Lime Down

Solar Park

Written Summary of the Applicant's Oral Submissions and Responses at Issue Specific Hearing 3 and Responses to Action Points

Document Reference: EXAM/9.50

INDICATIVE

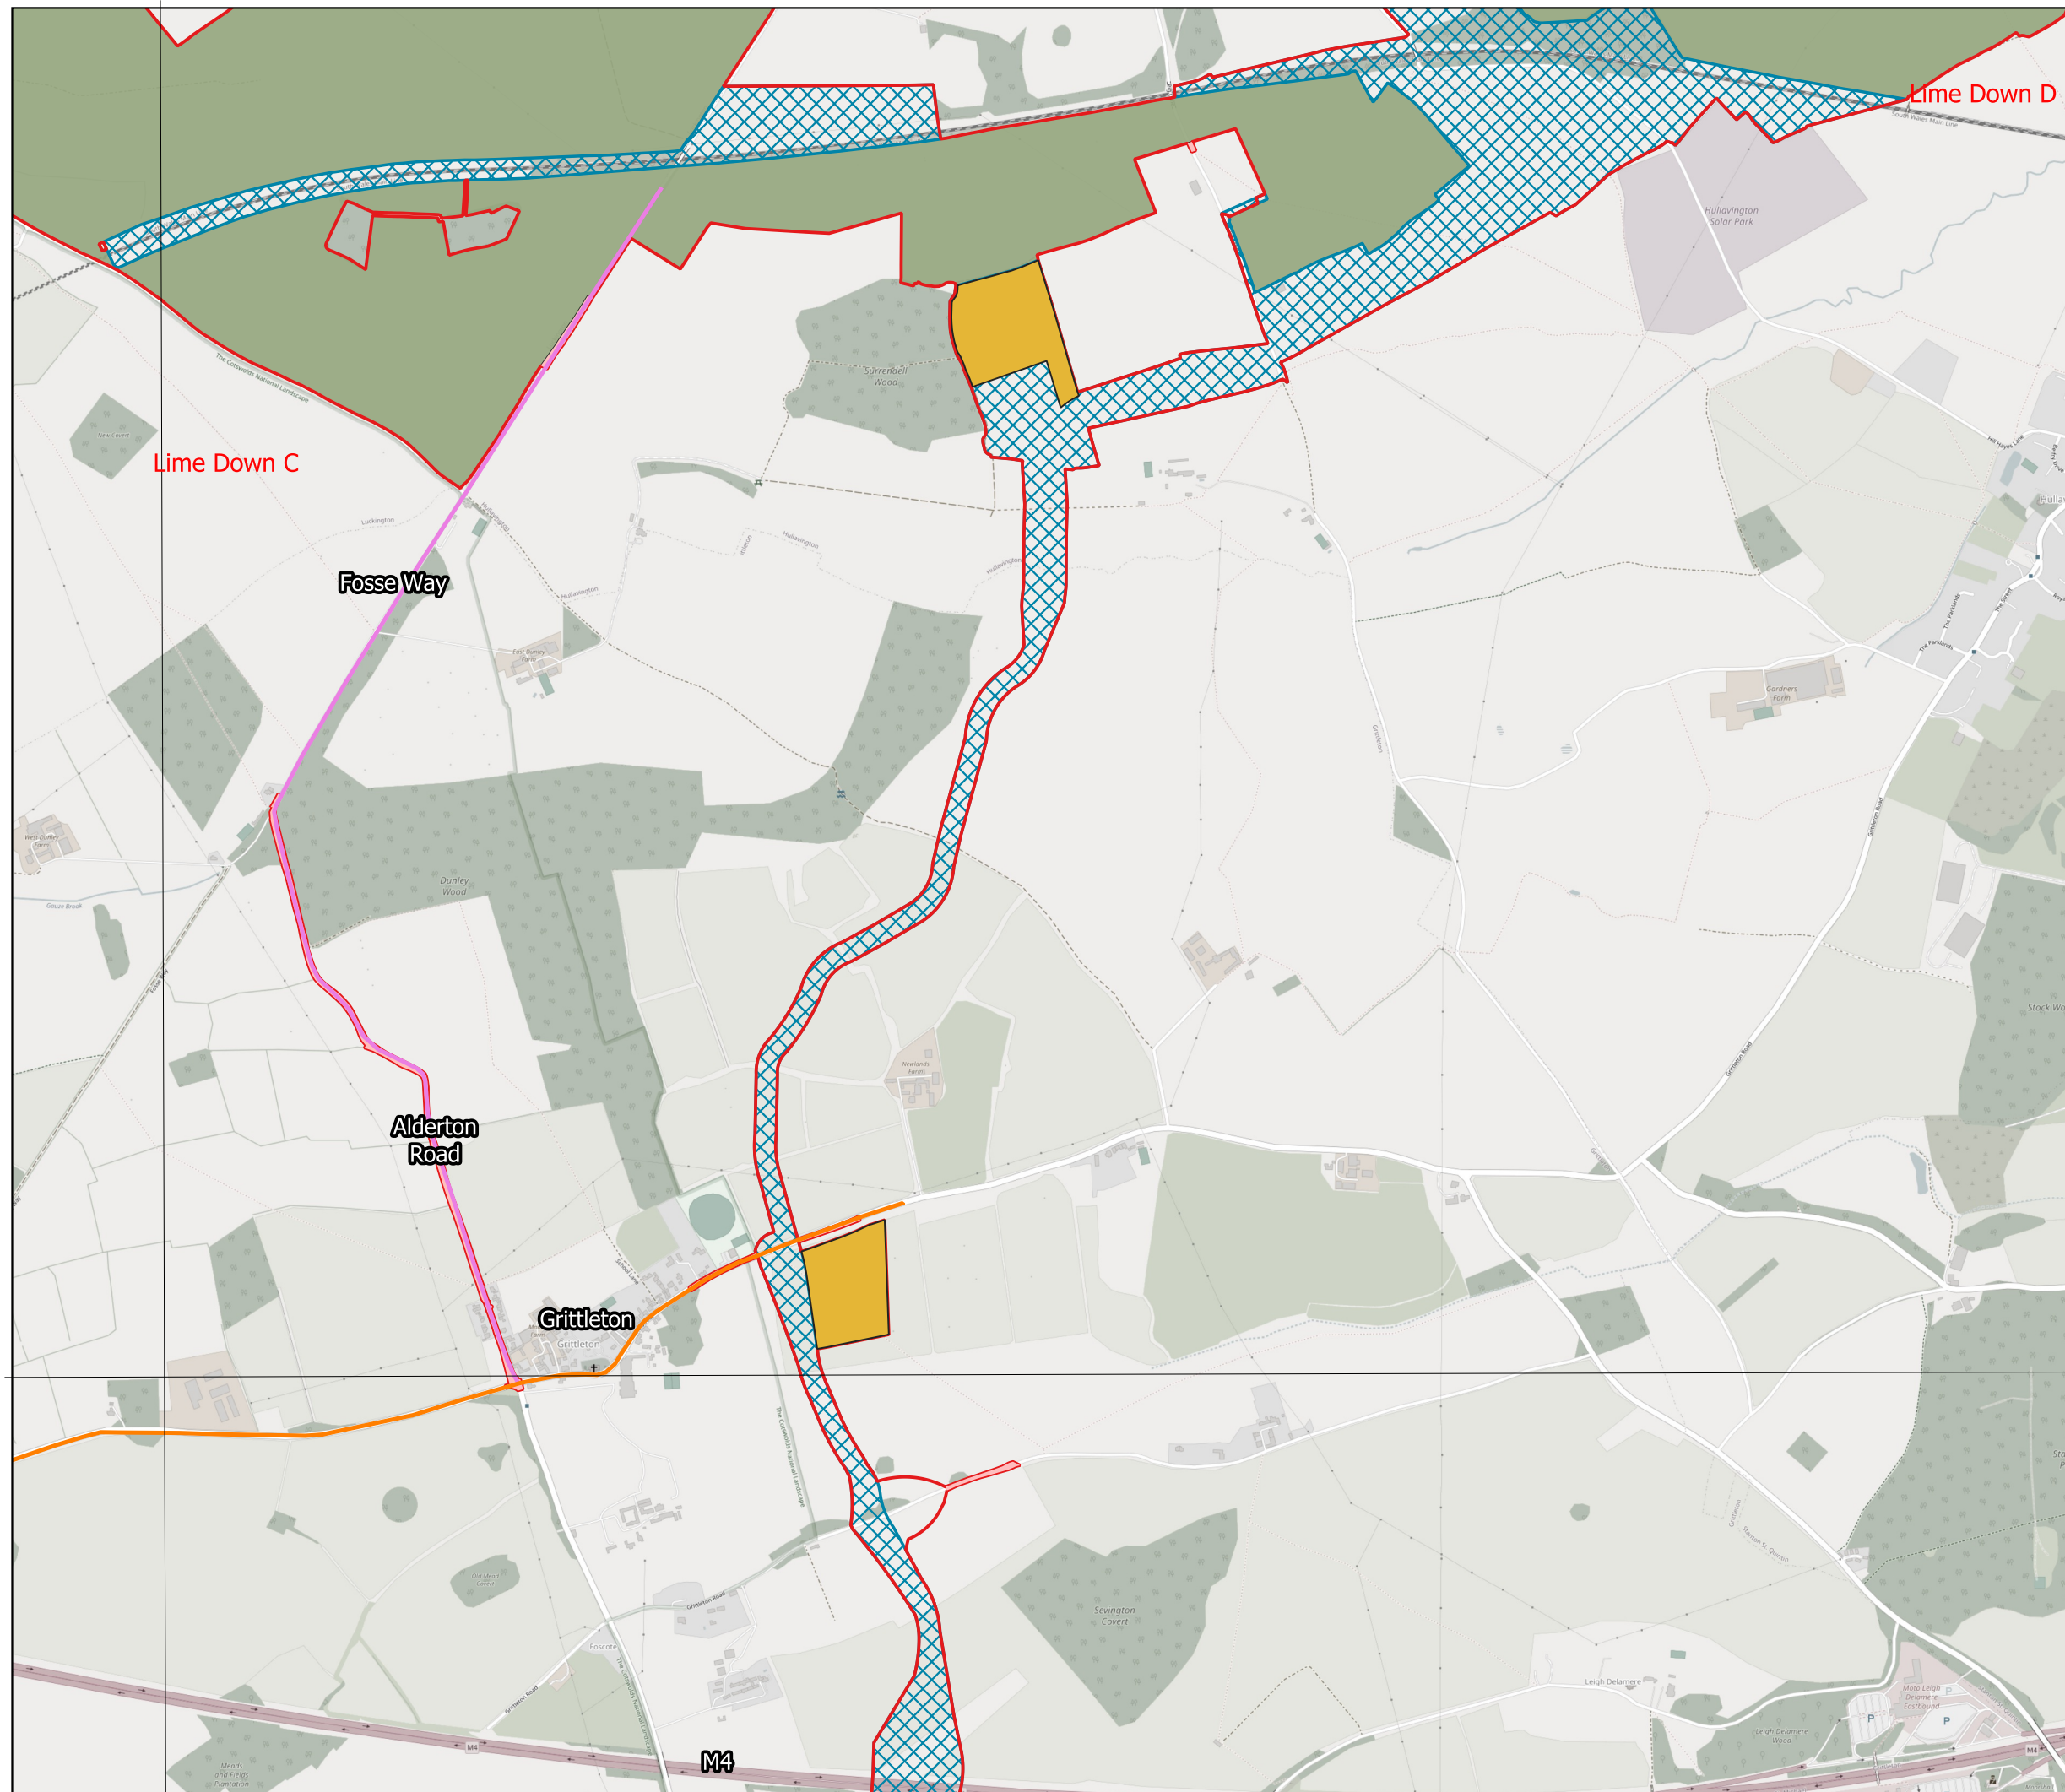
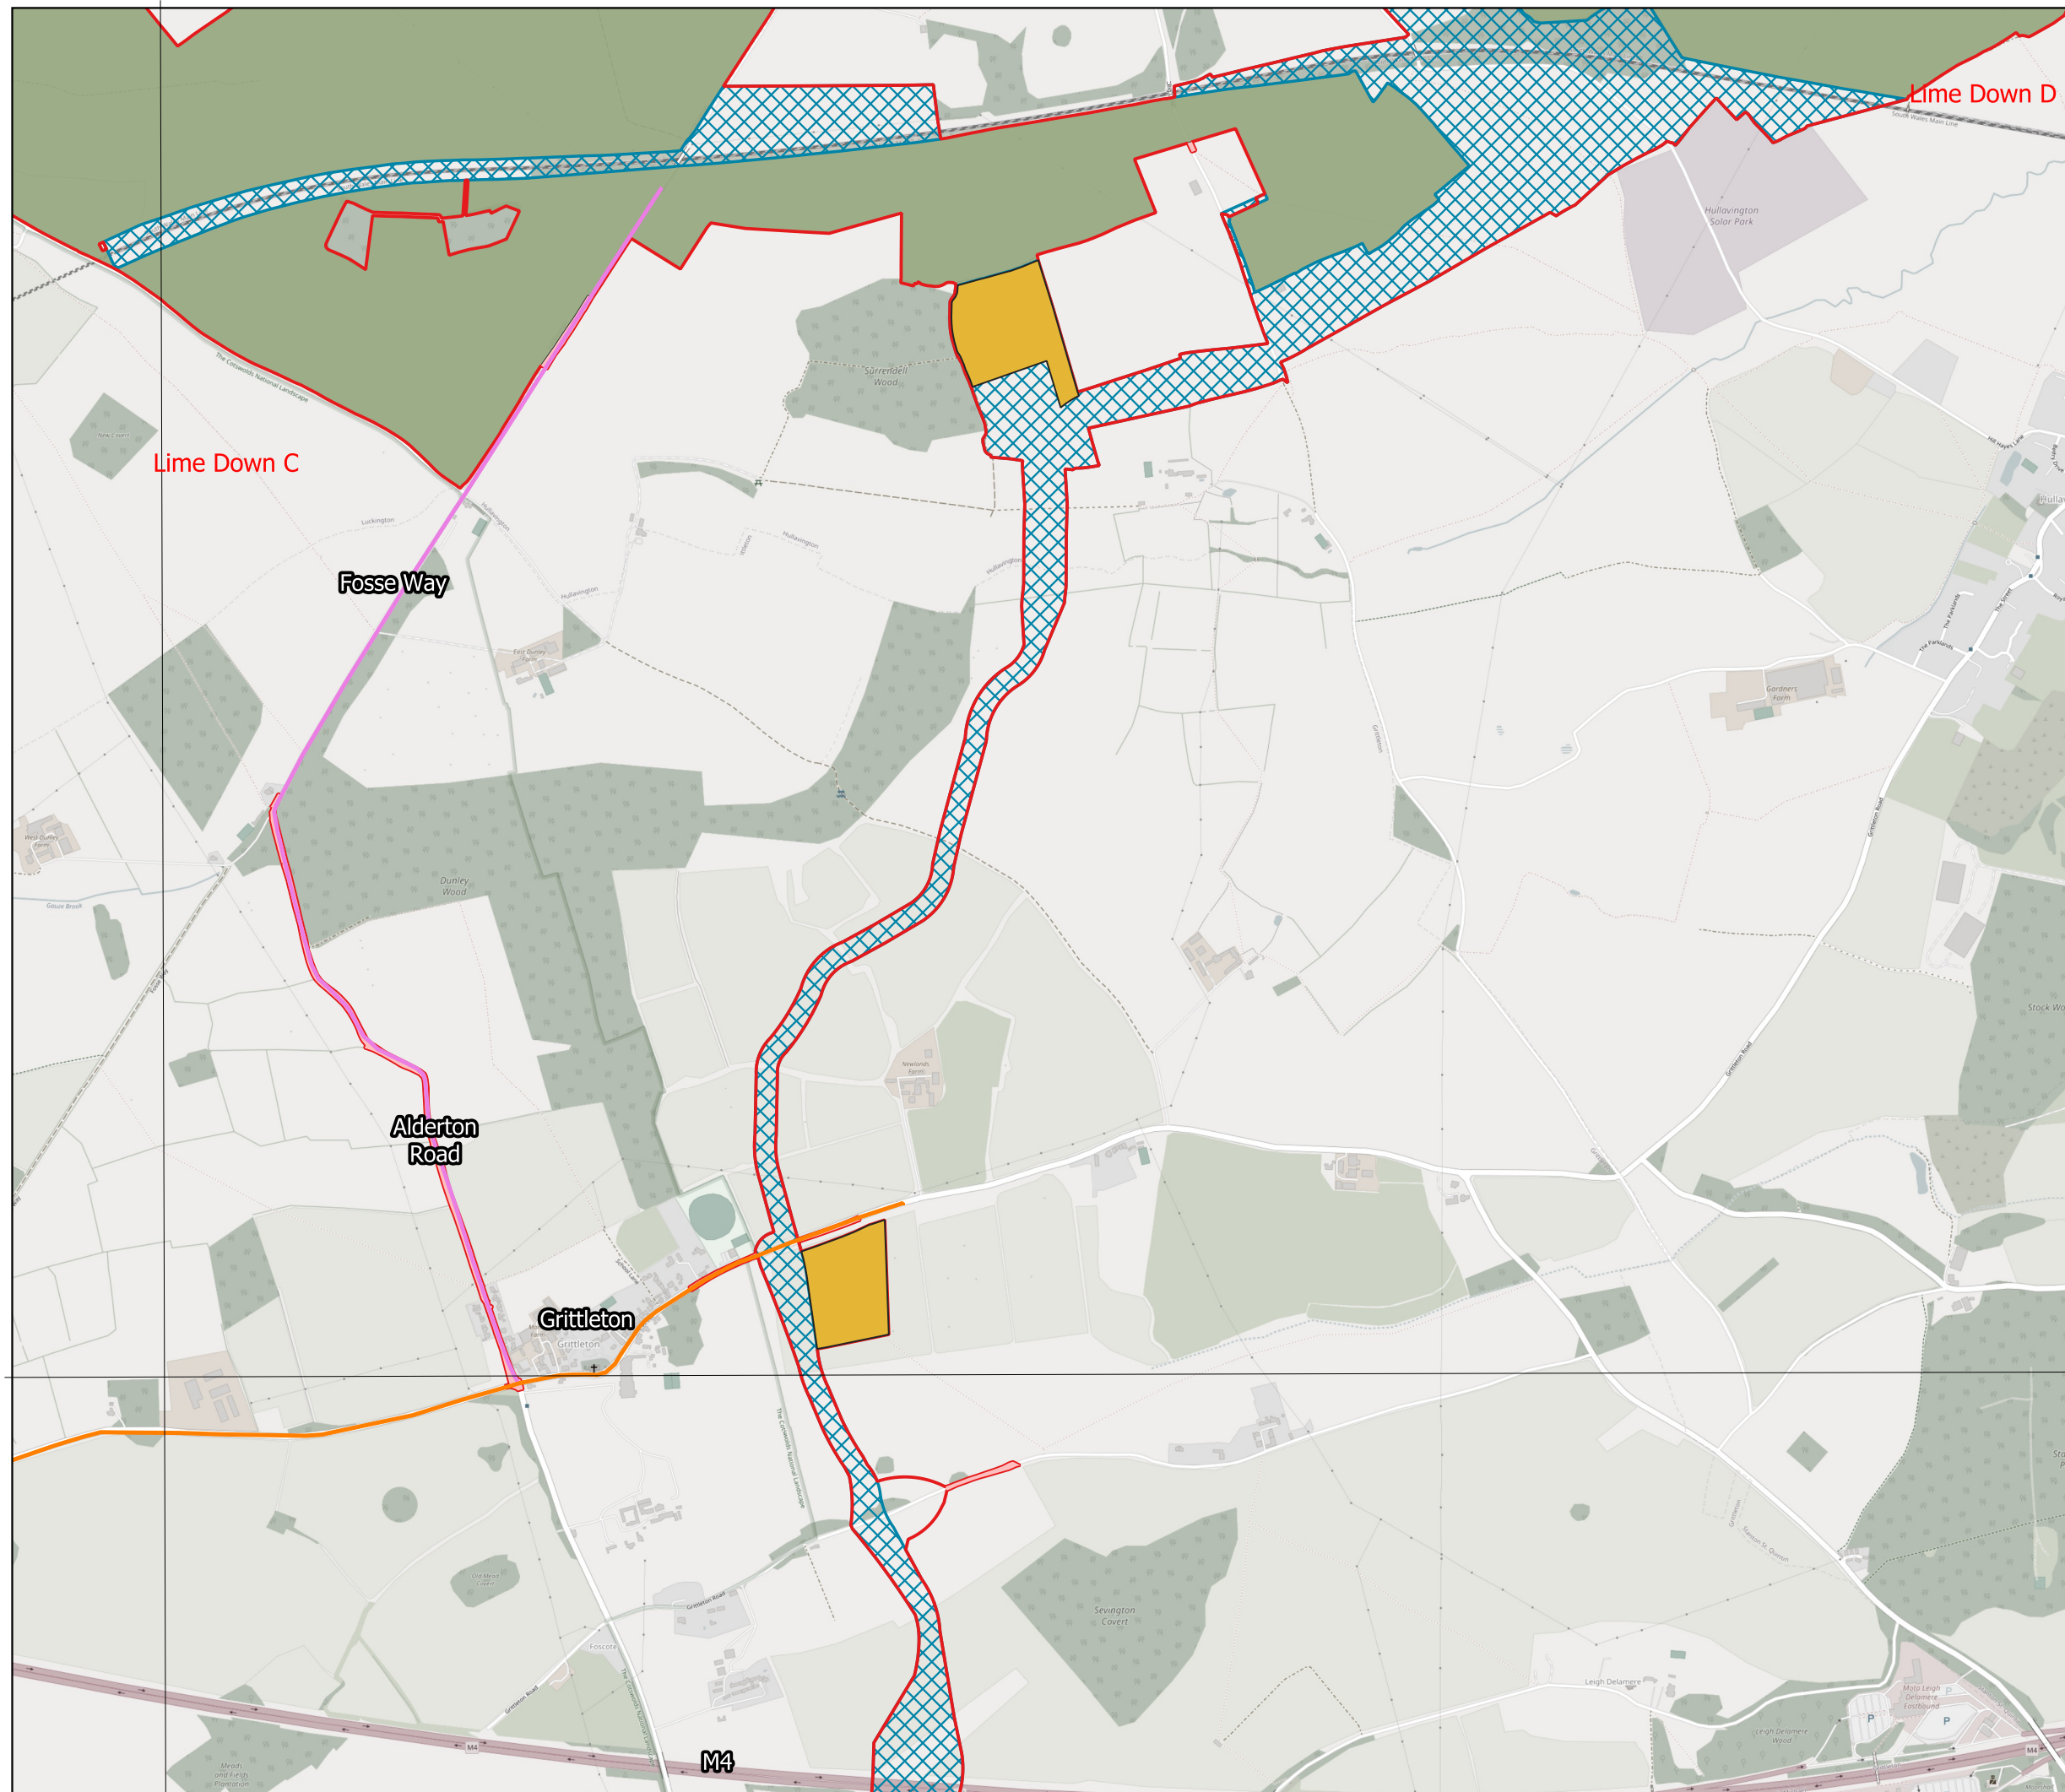
4.	Applicant	Provide a plan to show AIL turning circle at Fowlswick Lane compound to demonstrate the Cable AIL Route 2 will not proceed northwards through Yatton Keynell. For all other AIL routes, if AIL vehicles are intended to follow their same routes in reverse after unloading, provide information to confirm those	Deadline 4	Addressed in the post hearing note at agenda item 2.1 of this written summary.

Agenda item	Comment
	Mr Darrall confirmed that metal plating or matting would be used in this location, that there would be no other vehicle movements, and that the total available space would be used. The ExA referred to loss of tree cover discussed at the site inspection. Mr Threlfall believed the swept path document would confirm the position there. Ms Chalaby confirmed the notice period is 2 clear working days to the police, with 5 working days required for the authority to check for any structures on the route that would impede passage. Ms Brodrick on behalf of the Applicant confirmed there is no need to remove trees in this area. Reference was made to Rep 3066, the updated transport assessment, page 982, Annex J. The ExA asked about the alternative routes for Lime Down A and C (AIL), specifically whether Yatton Keynell could be an alternative. Mr Darrall referred to the purple route — A350, A420 — noting that AIL access to the north goes via Grittleton but does not go south of the railway line, it only goes as far as the construction compound as Fowlswick Lane. Mr Darrall confirmed the Applicant checked there is sufficient manoeuvring space for an AIL load of that type and that it would submit a plan showing this. <i>Post Hearing Note:</i> <i>The Applicant has provided AIL swept paths ES Volume 3, Appendix 13-1 Transport Assessment [REP3-065]. All AIL swept paths show the AIL vehicle entering and exiting each access. On exit, the cab is unhitched from the front of the trailer and driven to the back of the trailer and hitched up, then drives off in forward gear. A turning area for the whole AIL vehicle and trailer is not required as the AIL trailers are modular. ES Volume 2, Abnormal Load Routes - Solar PV Sites [EN010168/APP/6.2] (Revision 2) and ES Volume 2 Figure 13-6</i>

Agenda item	Comment
	<i>Abnormal Load Routes - Cable Route Corridor [EN010168/APP/6.2] (Revision 2 have been updated and submitted at Deadline 4. The update figures show AIL routing to the cable route compound on Fowlswick Lane.</i> <i>A plan is provided for Fowlswick Lane which is set out in Annex D of ES Volume 3 Appendix 13-1: Transport Assessment [REP3-065] (Drawing PL109B).</i> Mr Bamber on behalf of Stop Lime Down raised the issue of notice periods for AIL, noting a temporary traffic regulation order may be required. Mr Bamber requested the Applicant to confirm information on the process and what steps need to happen. Other road traffic regulations were noted to be covered separately. <i>Post Hearing Note:</i> <i>The process for providing notice and the standard AIL process is now included at paragraph 5.5.2 to 5.5.3 in ES Volume 3, Appendix 13-1: Transport Assessment [EN010168/APP/7.22] (Revision 4) and at paragraph 1.7.17 to 1.7.18 of the Outline CTMP [EN010168/APP/7.22] (Revision 4) submitted at Deadline 4.</i>
